**Application No:** 20/01145/DISC

**Proposal:** Discharge of Condition 6 (contamination Investigation) 8 (remediation scheme) & 11 (Means of access) 18/02147/OUT

**Location:** Land north of Hempton Rd and west of Wimborne Close, Deddington

## Transport Development Control

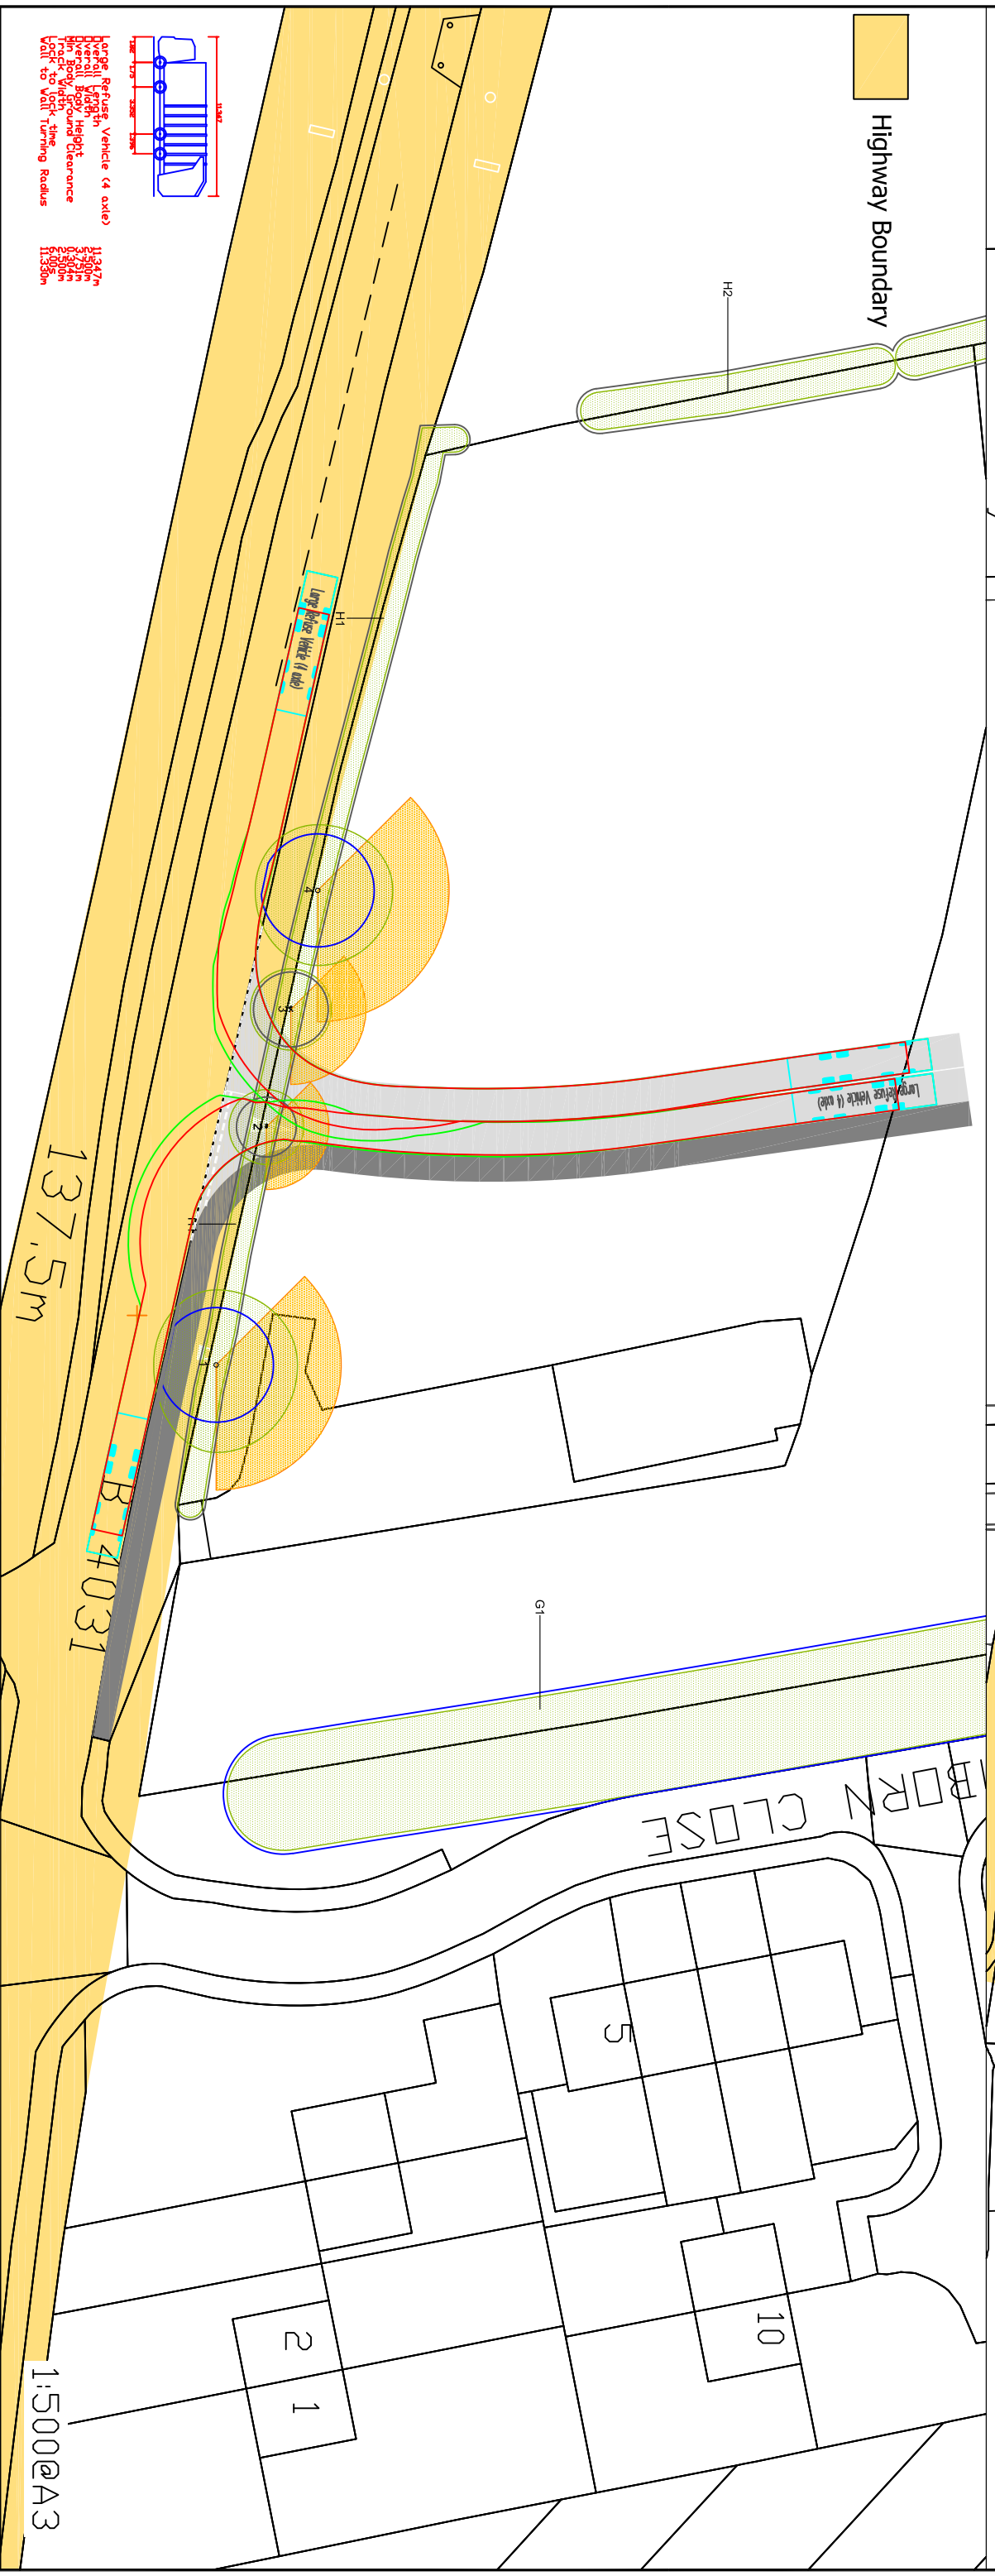
Condition 11              Objection

The submitted plan contains insufficient detail to discharge condition 11. OCC Road Agreements need to receive a S278 application before they are able to approve the proposed details.
